WEST SUSSEX COUNTY COUNCIL CONSULTATION

TO:	Arun District Council FAO: Raymond Cole
FROM:	Stephen Gee WSCC - Highways Authority
DATE:	17 April 2020
LOCATION:	Land at Ford Airfield Ford, West Sussex
SUBJECT:	F/4/20/OUT Outline planning application (with all matters reserved except for access) for the development of up to 1,500 dwellings (Use Class C3), 60-bed care home (Use Class C2), up to 9,000 sqm of employment floorspace (Use Classes B1), local centre of up to 2,350 sqm including up to 900 sqm retail / commercial (Use Classes A1-A5) and 1,450 sqm community / leisure floorspace (Use Classes D1-D2), land for a two-form entry primary school (Use Class D1), public open space, allotments, new sports pitches and associated facilities, drainage, parking and associated access, infrastructure, landscape, ancillary and site preparation works, including demolition of existing buildings and part removal of existing runway hardstanding. This application affects a Public Right of Way. This application is the subject of an Environmental Statement. This application falls within CIL Zone 1 - Zero Rated.

T:\Projects\13000 Series\13091\118 Ford Airfield\Tech\Arch\Transport Drawings\Working Drawings\GA\ITB13091-GA-037.dwg

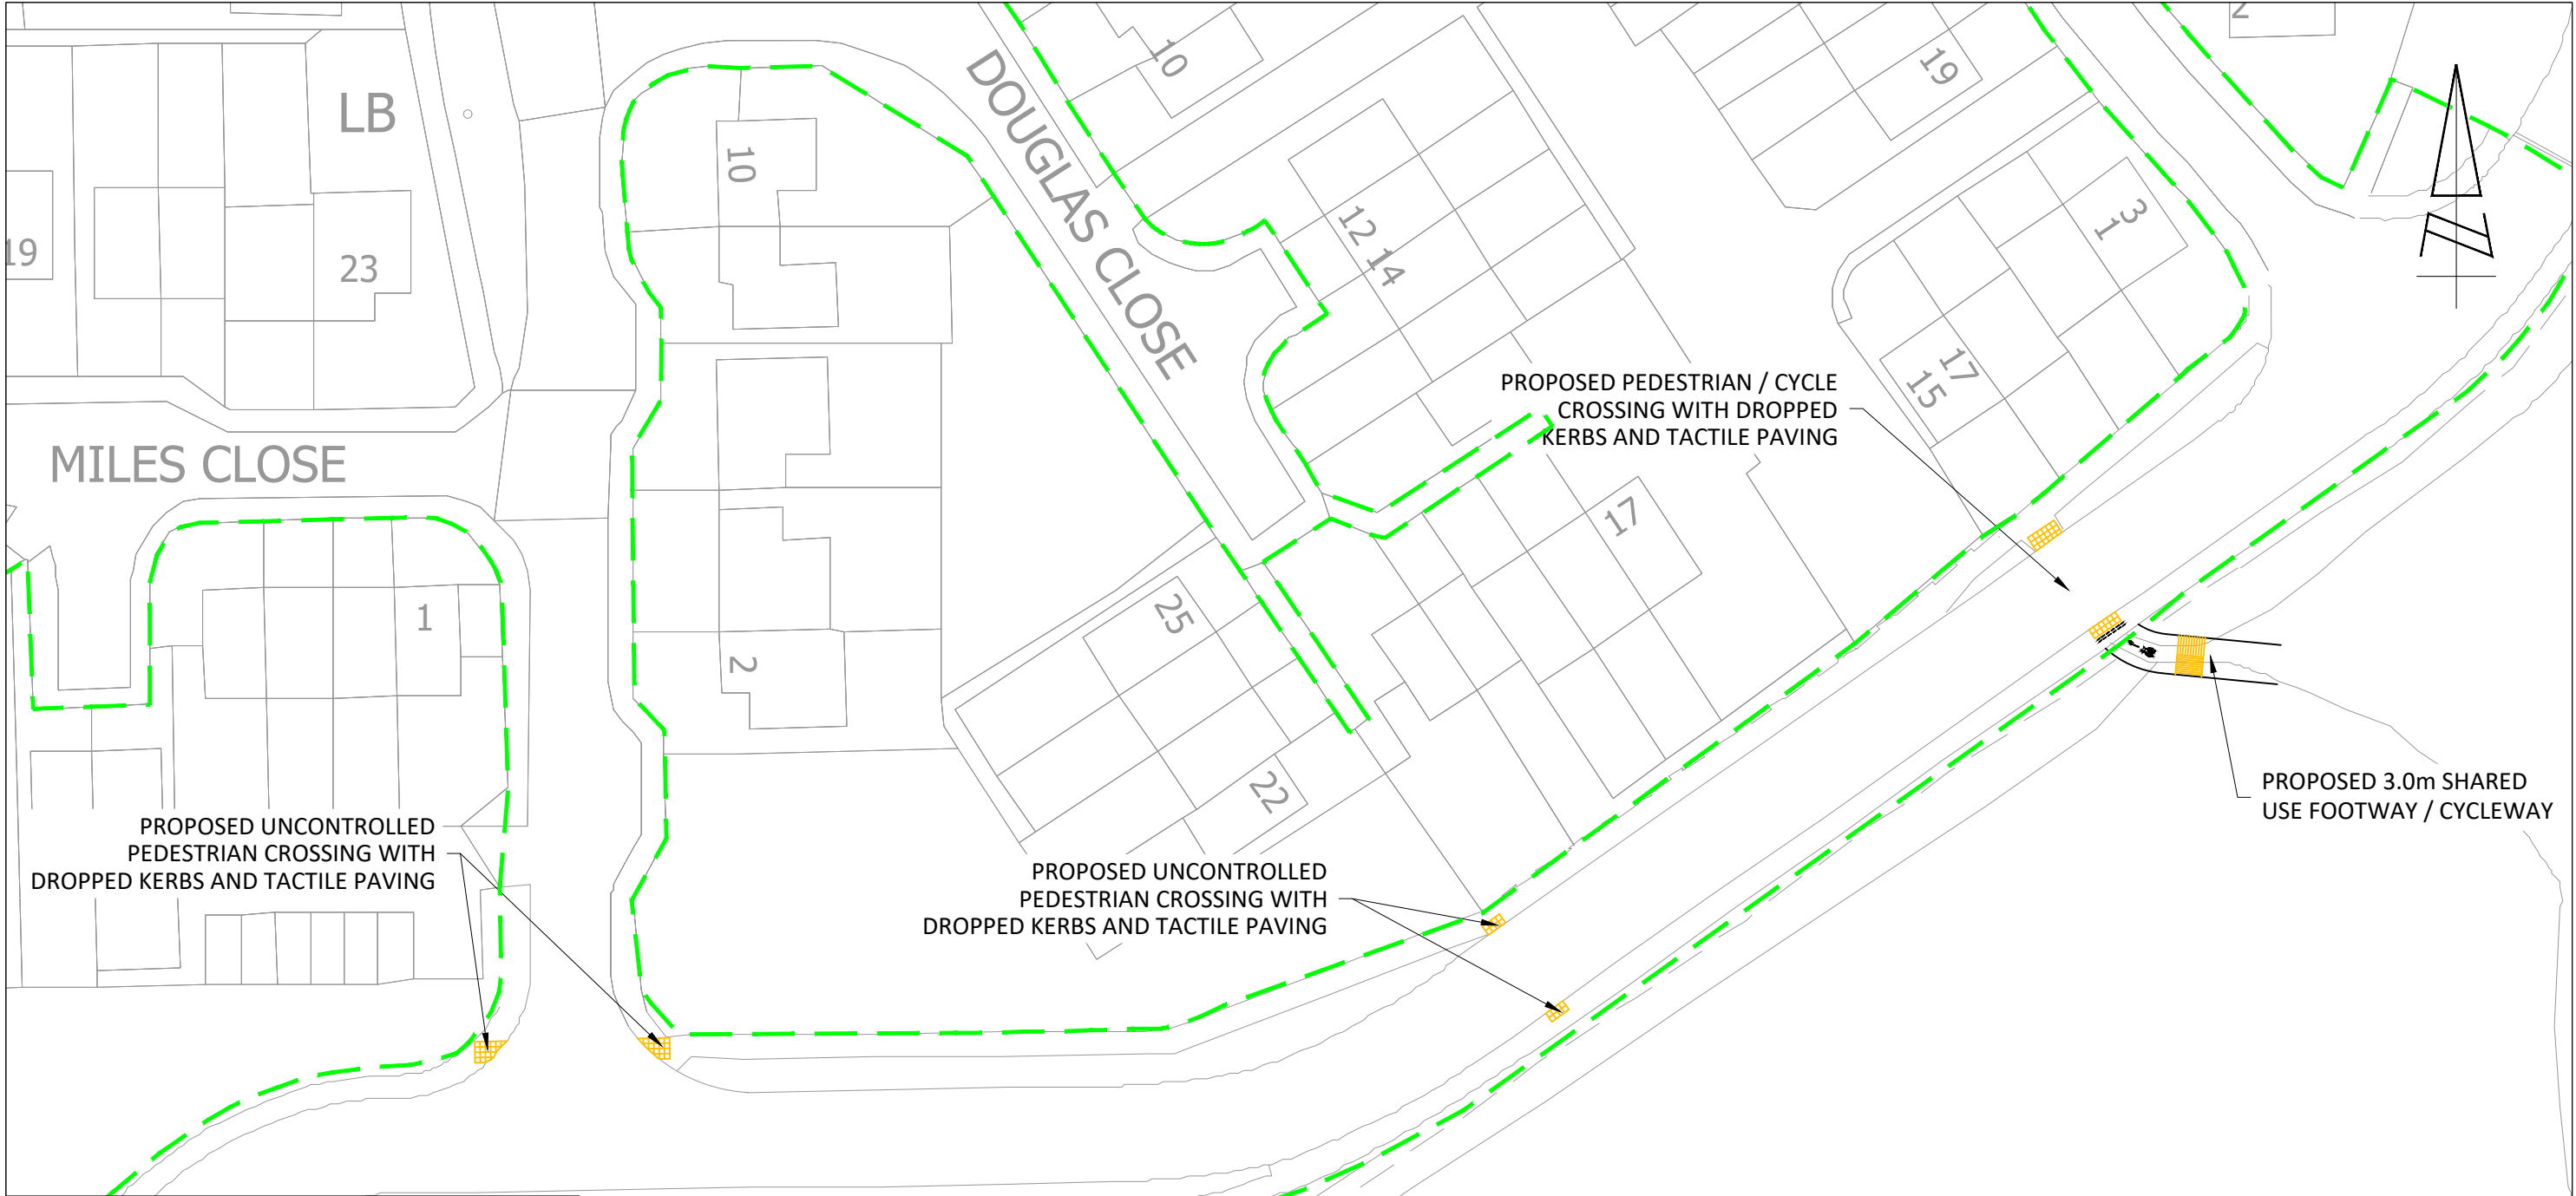
Within the site, the area identified for employment use will be accessed by the extension of the consented Grundon Access Road. The arrangement comprises the extension of the 7.3m carriageway as well as the 2.0m footway located on the western side of the carriageway. The access arrangement is presented in drawing ITB13091-GA-037.

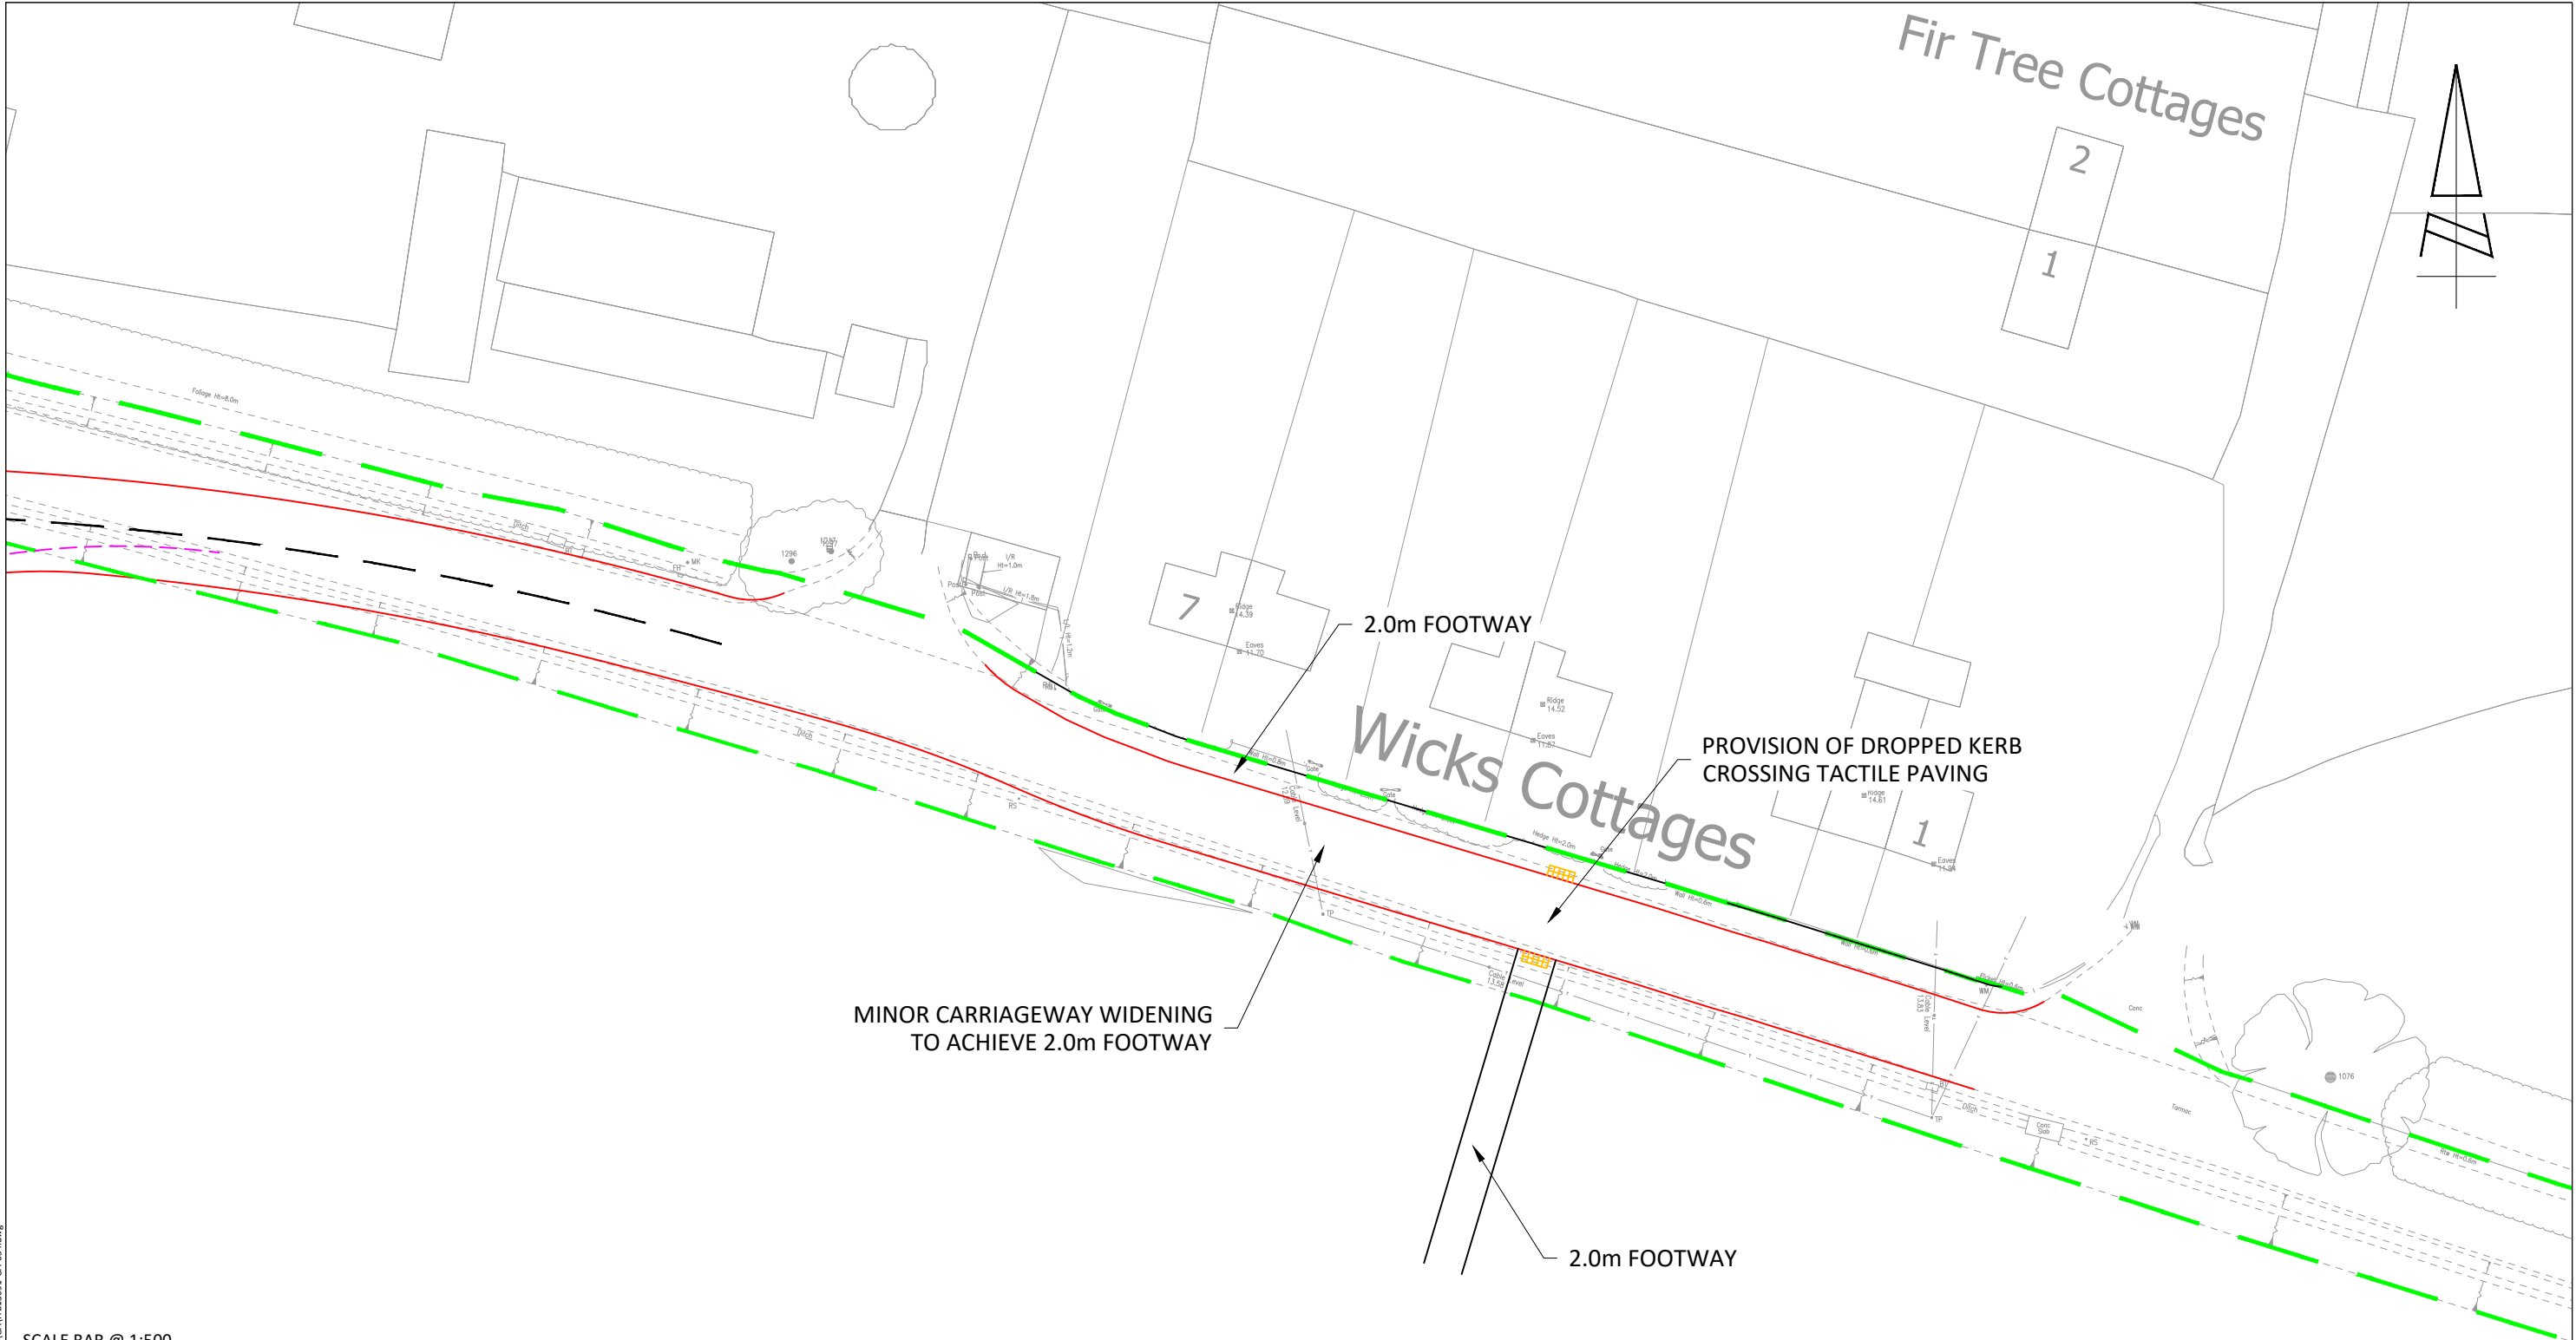
A 3m wide shared use facility would be provided from Horsemere Green Lane into the development, cyclists would then be on road until joining a shared use route adjacent to the Church Lane carriageway and onwards to the National Cycle Network Route2 and Climping Beach. The access arrangement is presented in drawing ITB13091-GA-042. The applicant should consider how the scheme would be delivered in combination with the permitted Climping allocation ref CM/1/17.

Details should also be provided of pedestrian facilities along Horsemere Green Lane and any necessary improvements.

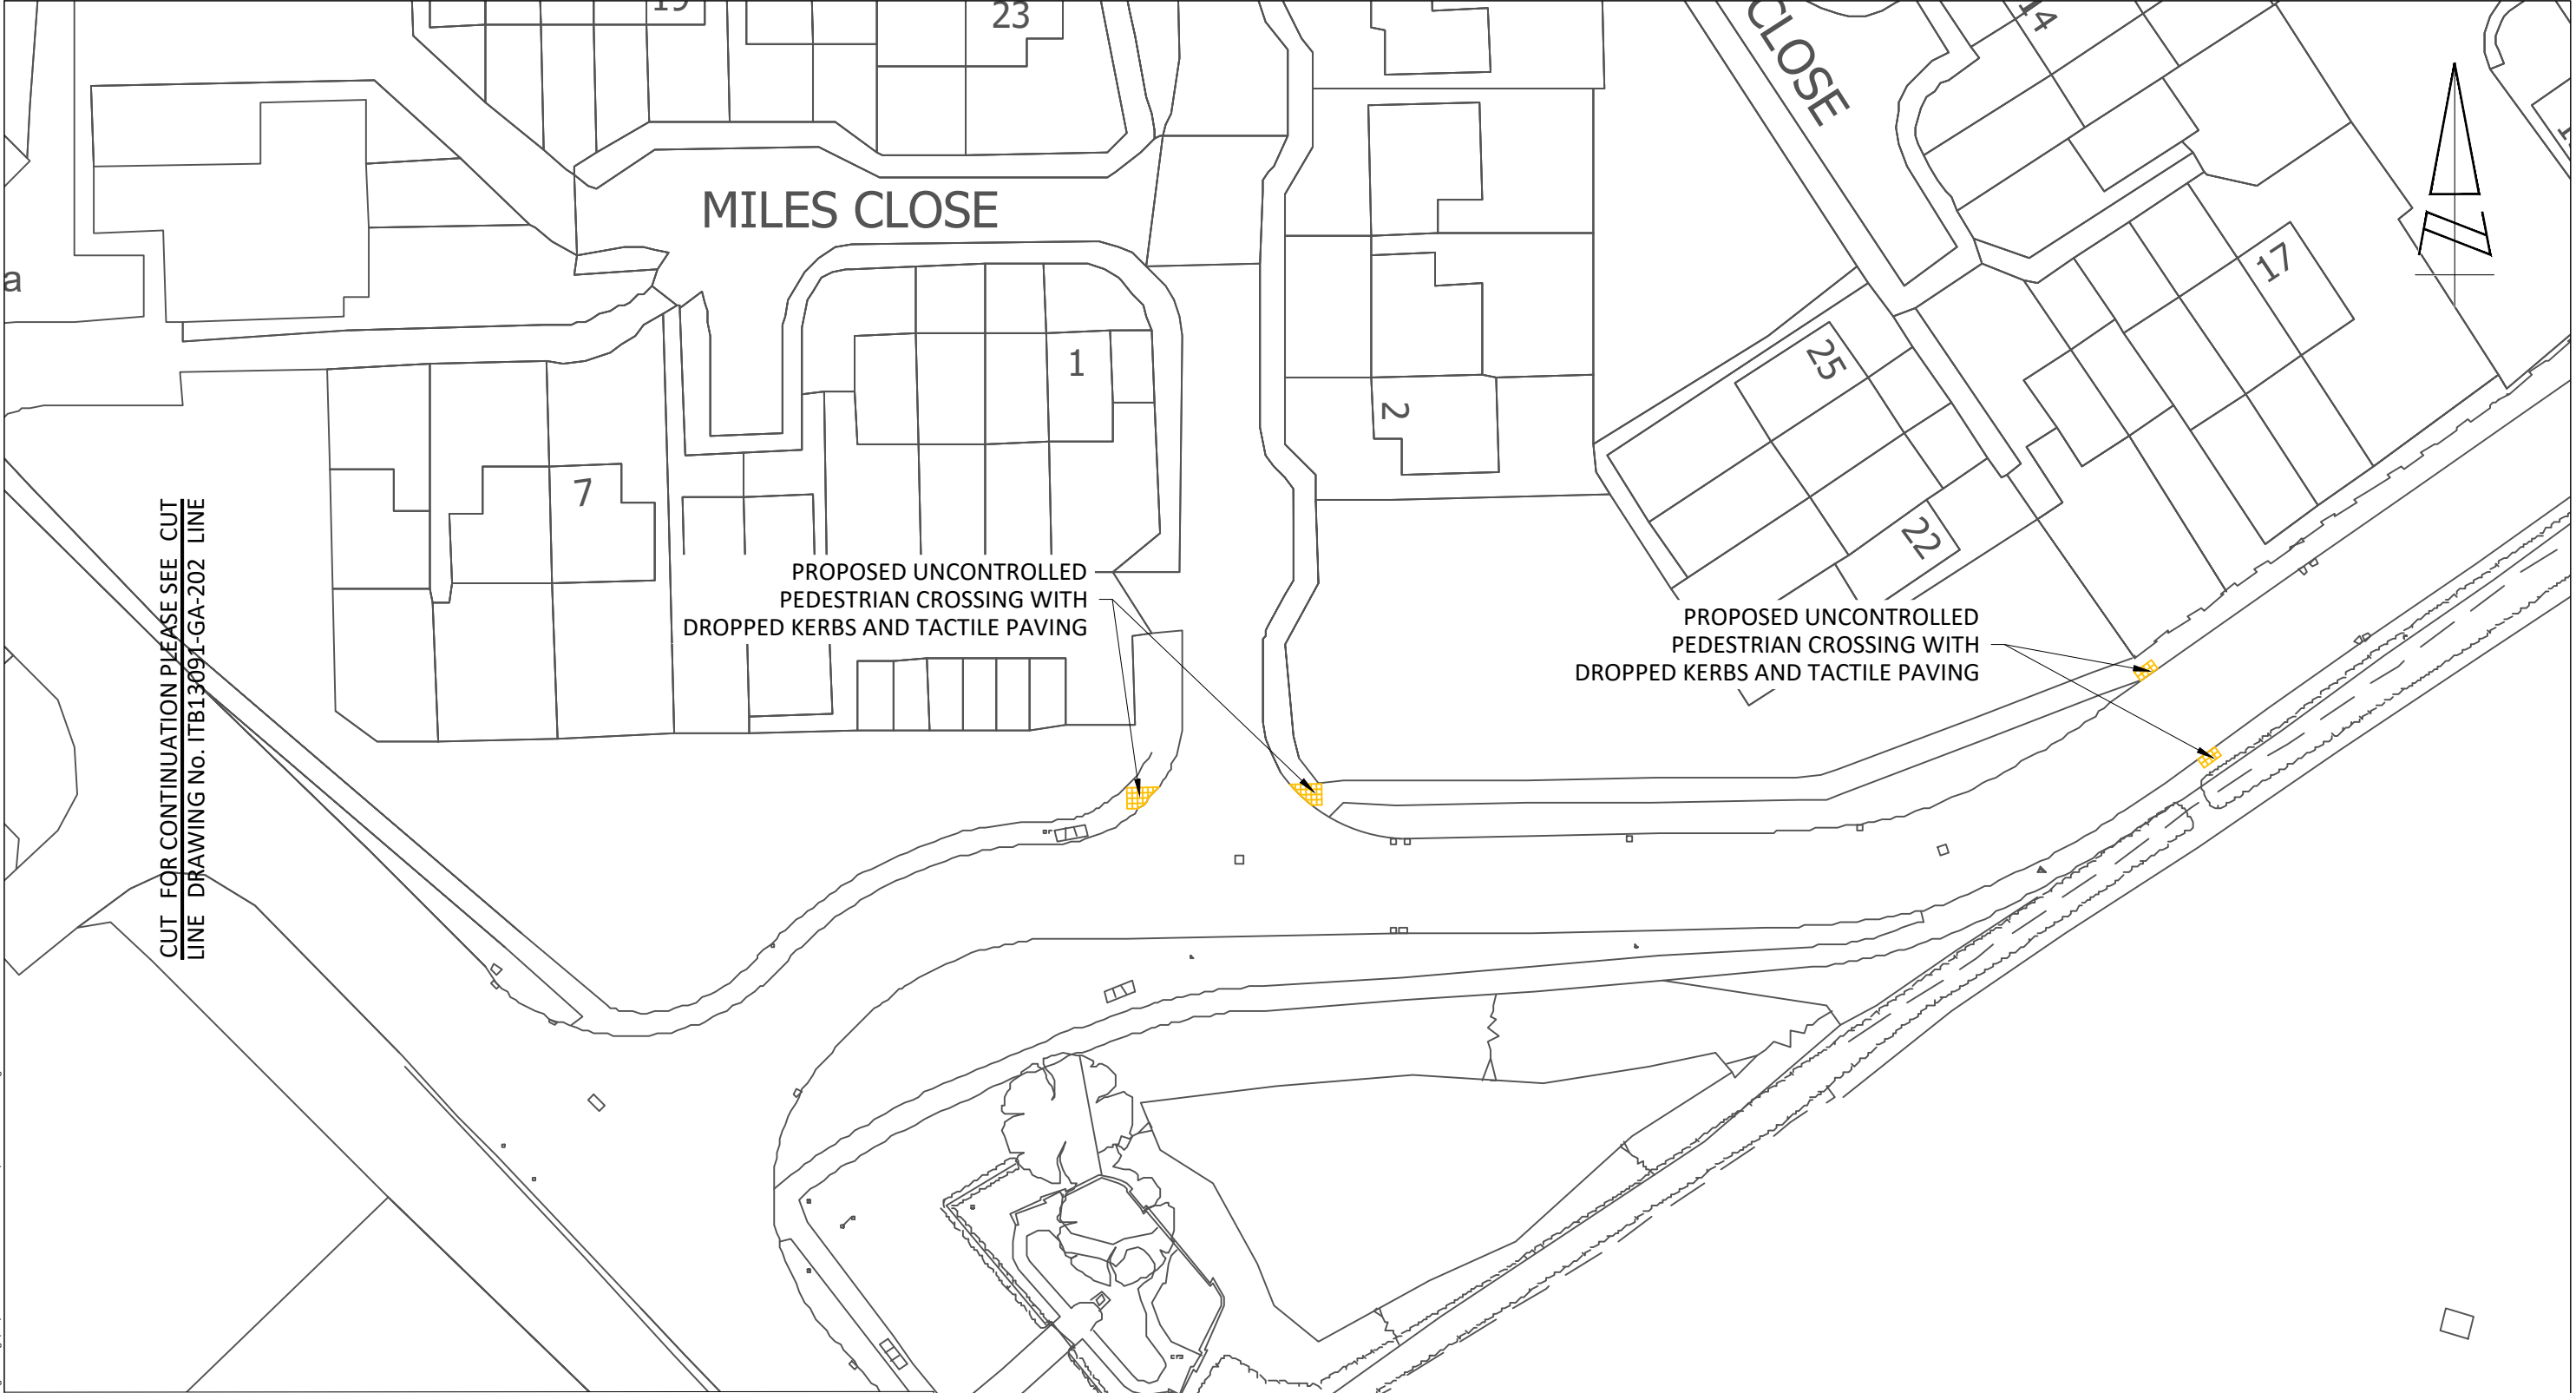
A 2m wide footway is to be provided onto Ford Lane and an adjacent footway provided in front of Wickes Cottages. As shown on ITB13091-GA-054. The full extent of the

provision in both directions along Ford Lane should be identified to determine a safe termination point.
